Consultation Response from KC Conservation and Design
2018/92687 former Kirklees College, New North Road, Huddersfield, HD1 5NN
Listed Building Consent for alterations, demolition of part the grade ii* listed building and other curtilage listed buildings (within a Conservation Area)
Date Responded: 9.10.20 Responding Officer: Sue Oakley Responding Ref:

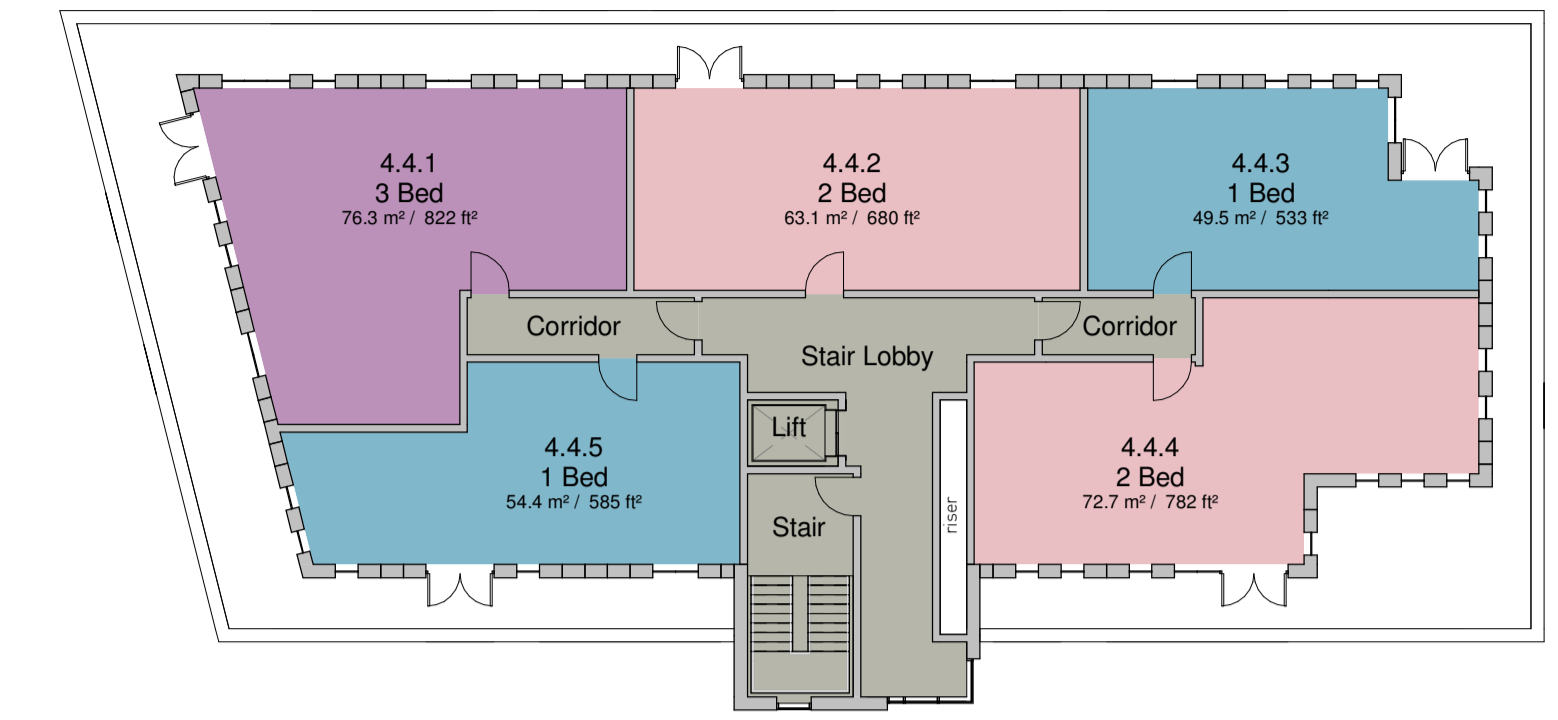
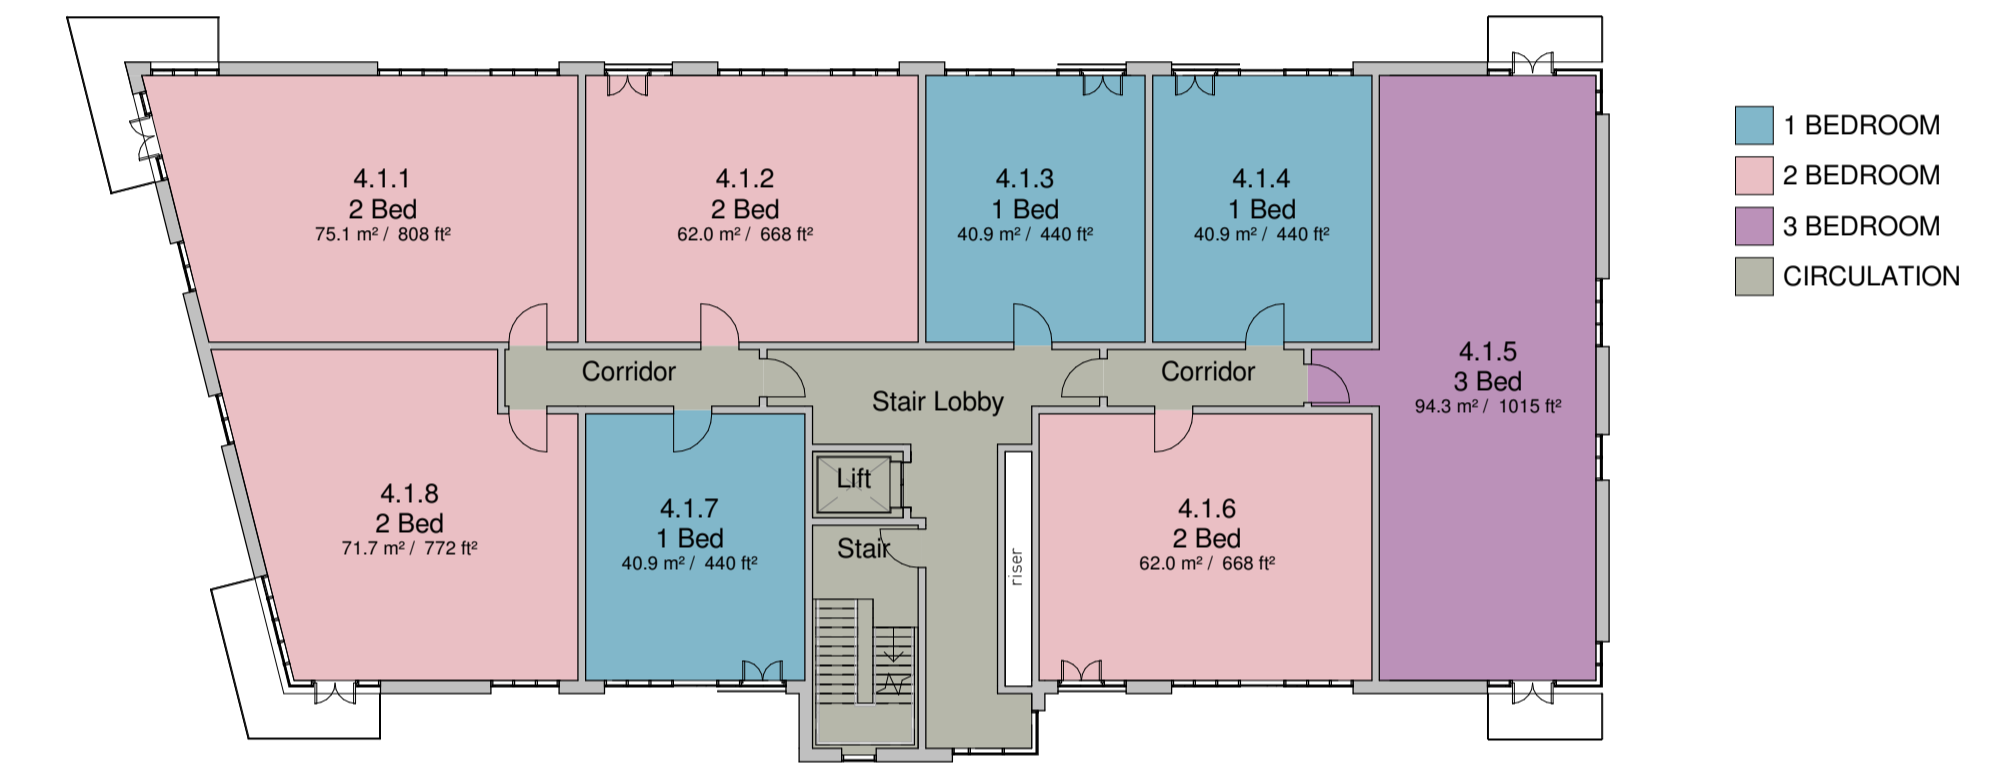
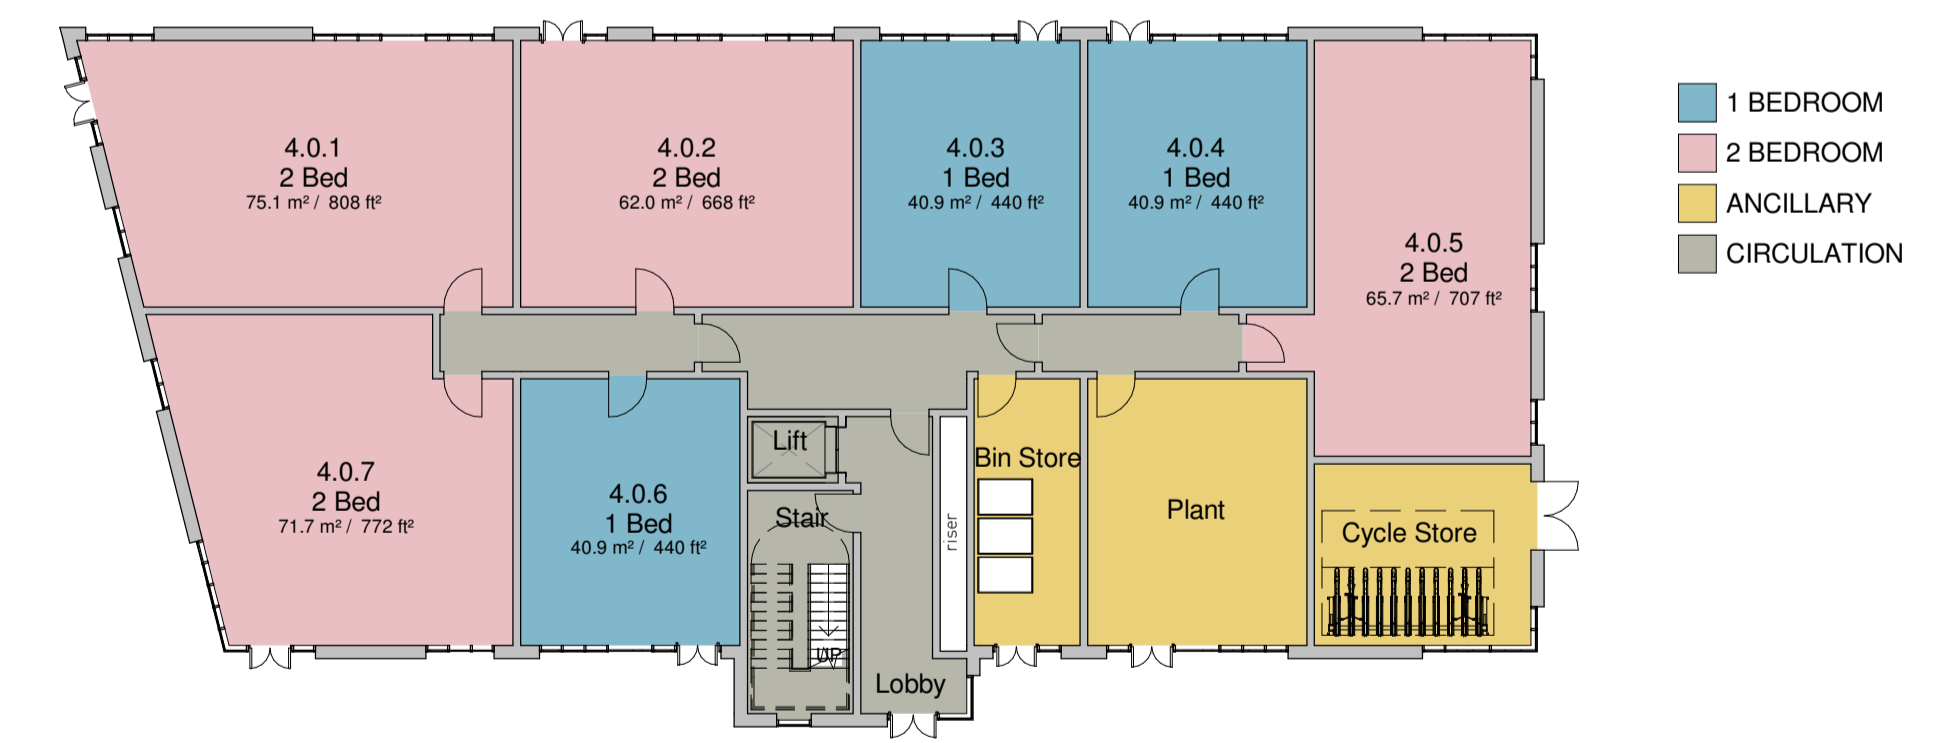
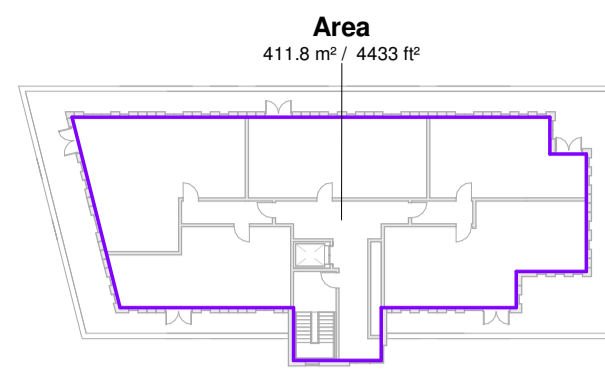
I am concerned about the design, scale and positioning of building 5 and its dominance over the two-storey listed infirmary building on the site as well as the listed church and properties on New North Road, which would sit directly opposite this new structure. Historic maps from the late 19th and early 20th centuries indicate that there were terraced houses close to the boundary of the site at the northern end and the design and access statement has used this urban grain to inform the proposed footprint.

The heritage assessment states that the proposed height of buildings 4 and 5 reflects that of the existing buildings on the northern part of the site, also reflecting the historic development that occurred prior to the construction of Building G (the terraced houses). However, the existing multi-storey buildings are set back from the north and east boundaries and I would consider building 5 to have significantly more impact on the infirmary and surrounding listed buildings than the existing structures due to its location directly on the site boundary.

Given the fairly standard design of Buildings 4 and 5 and their dominance over the surrounding listed buildings, I would like to see amendments to their design, with more consideration given to the immediate context and with the retention of elements of Building G. I consider that in their current form these elevations harm the setting of the listed buildings, in particular the infirmary and St Patrick's Church, and while I understand that the site is in need of improvement, they should be redesigned to complement their setting.

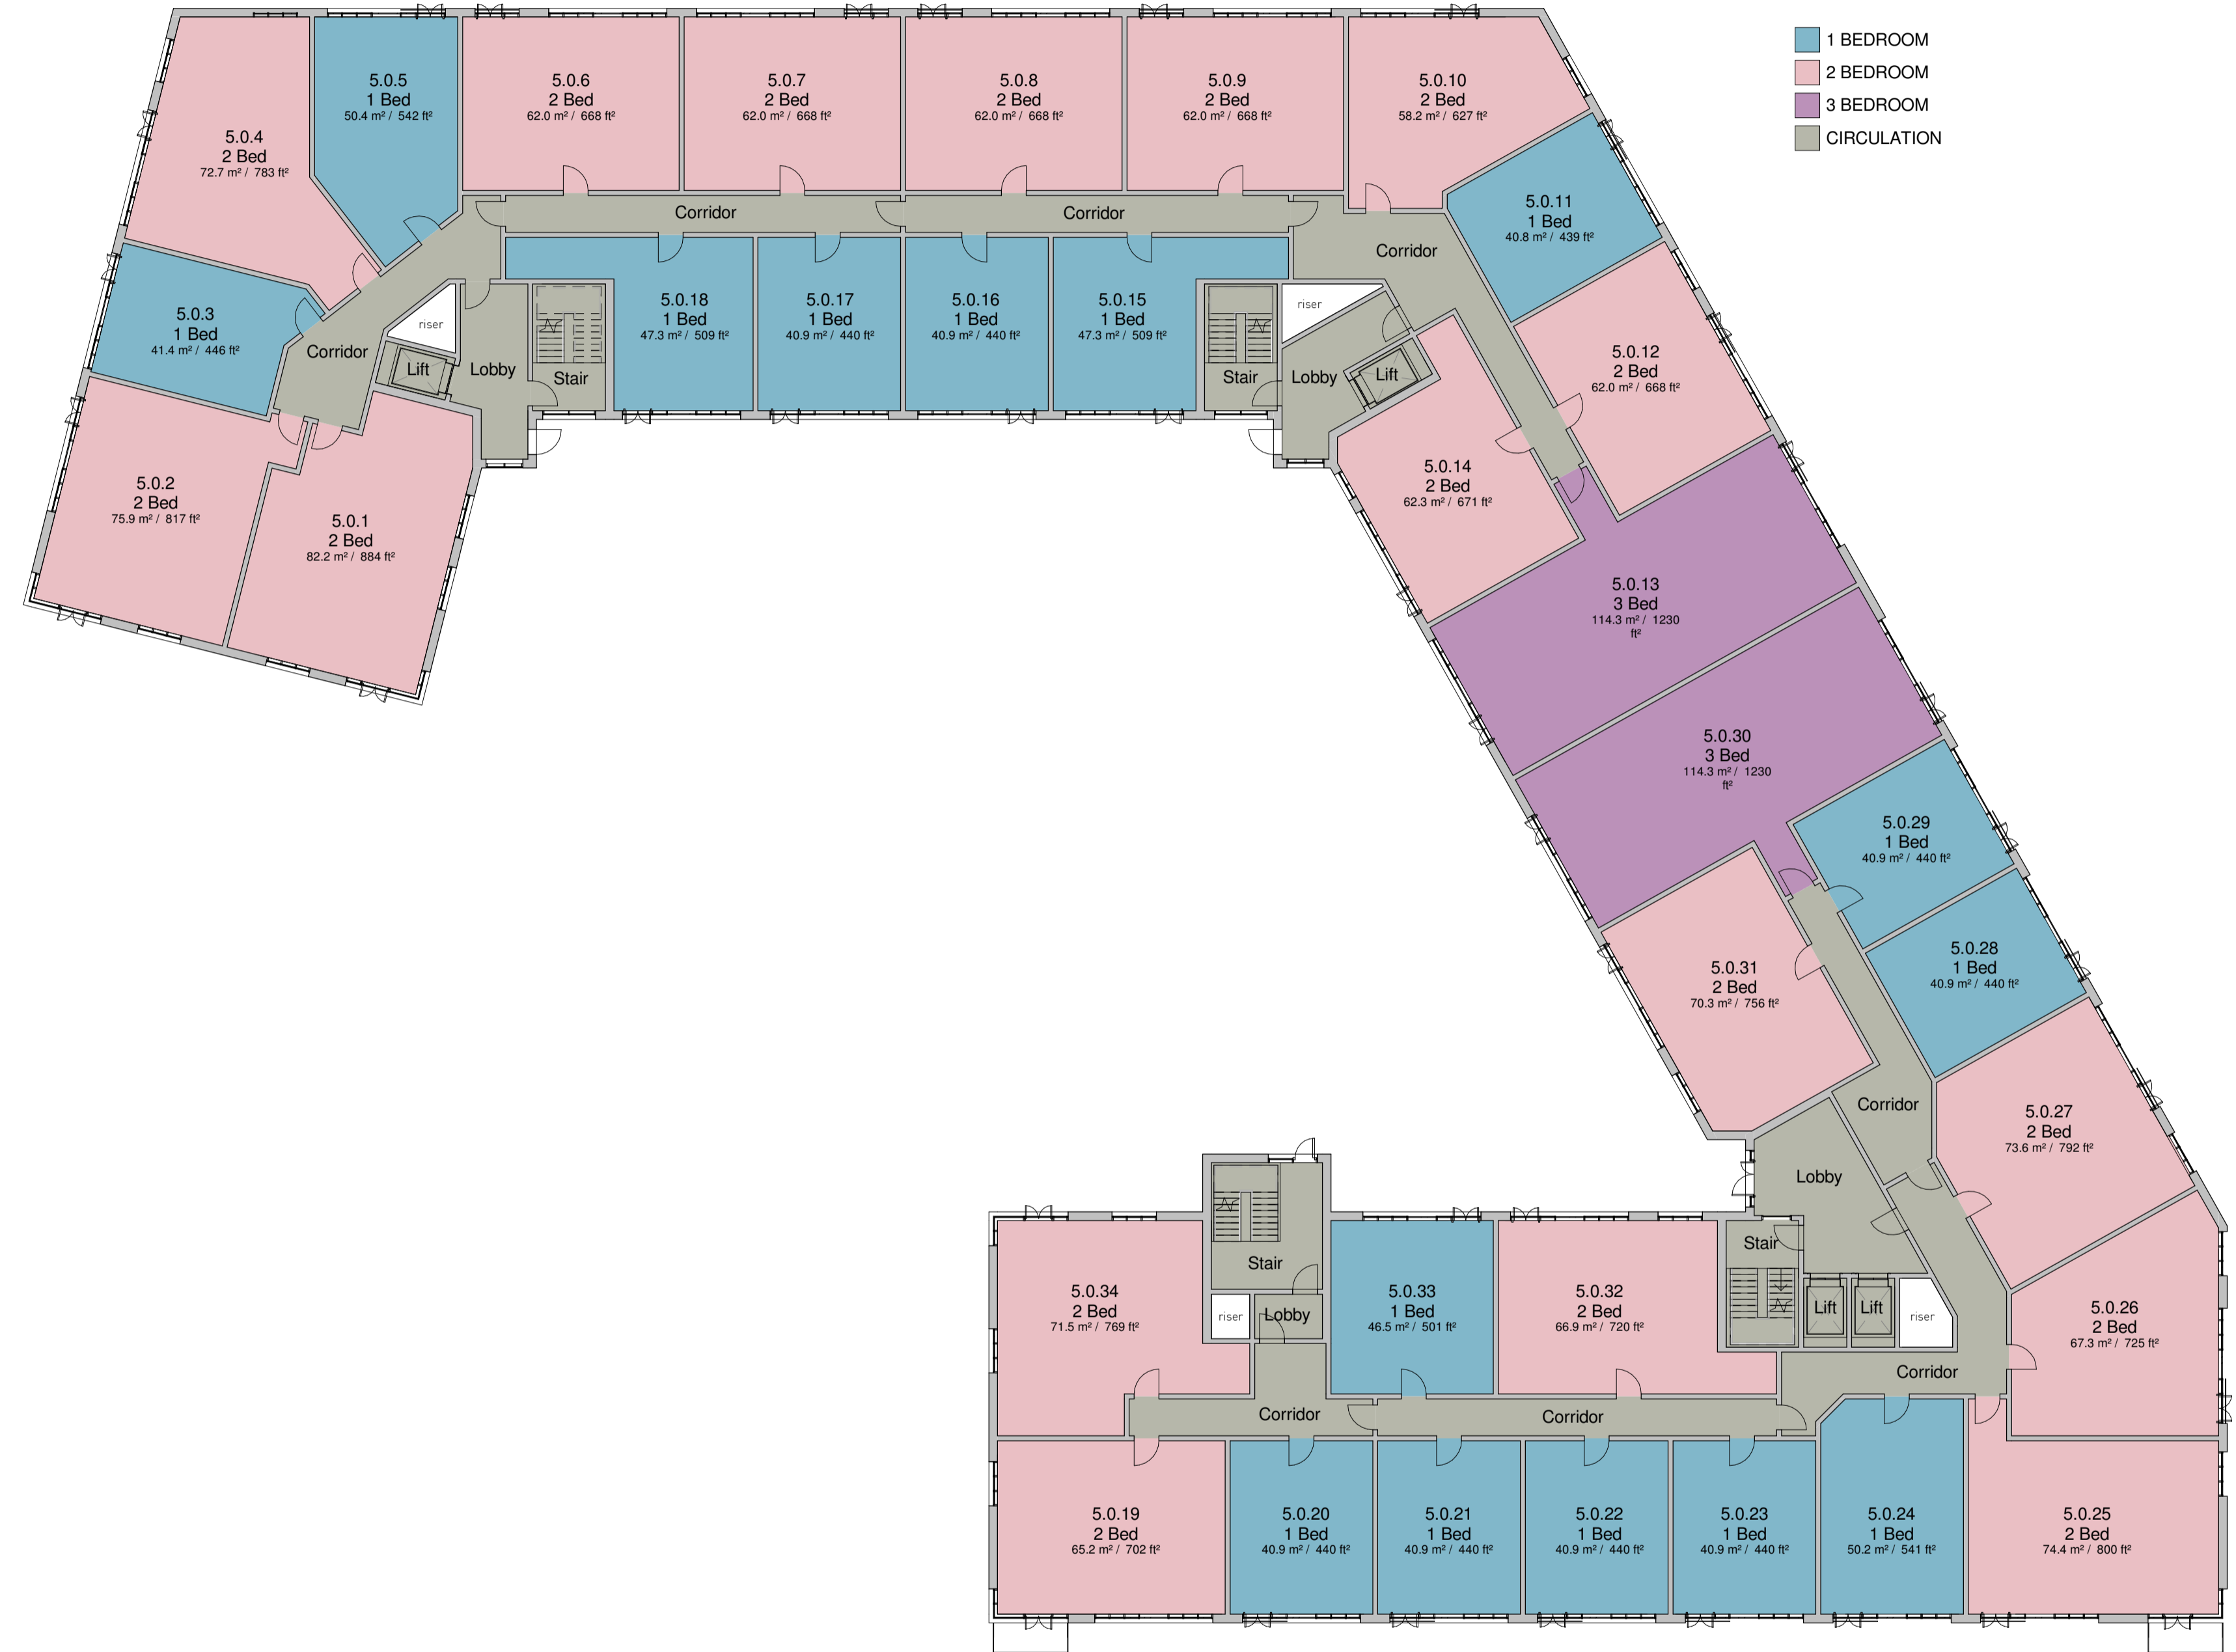
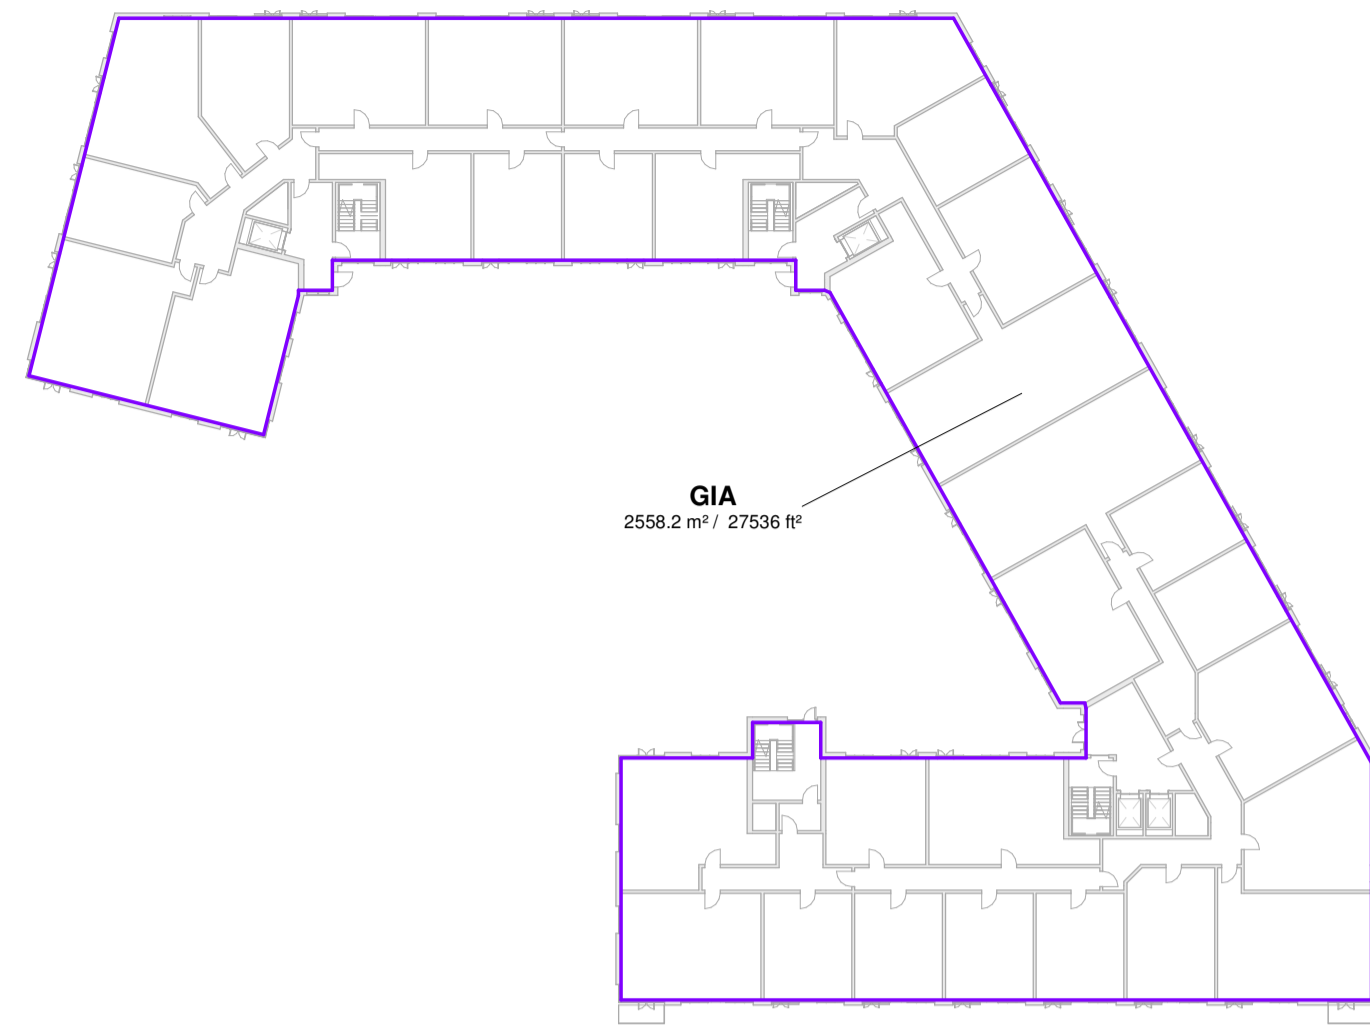
To the north of the site are three Grade II listed former dwellings, 112 to 116 Fitzwilliam Street, along with the listed boundary wall of number 112. I consider the impact of Building 5 on the setting of these listed buildings to be less, although the scale and design should also be considered carefully in this prominent location.
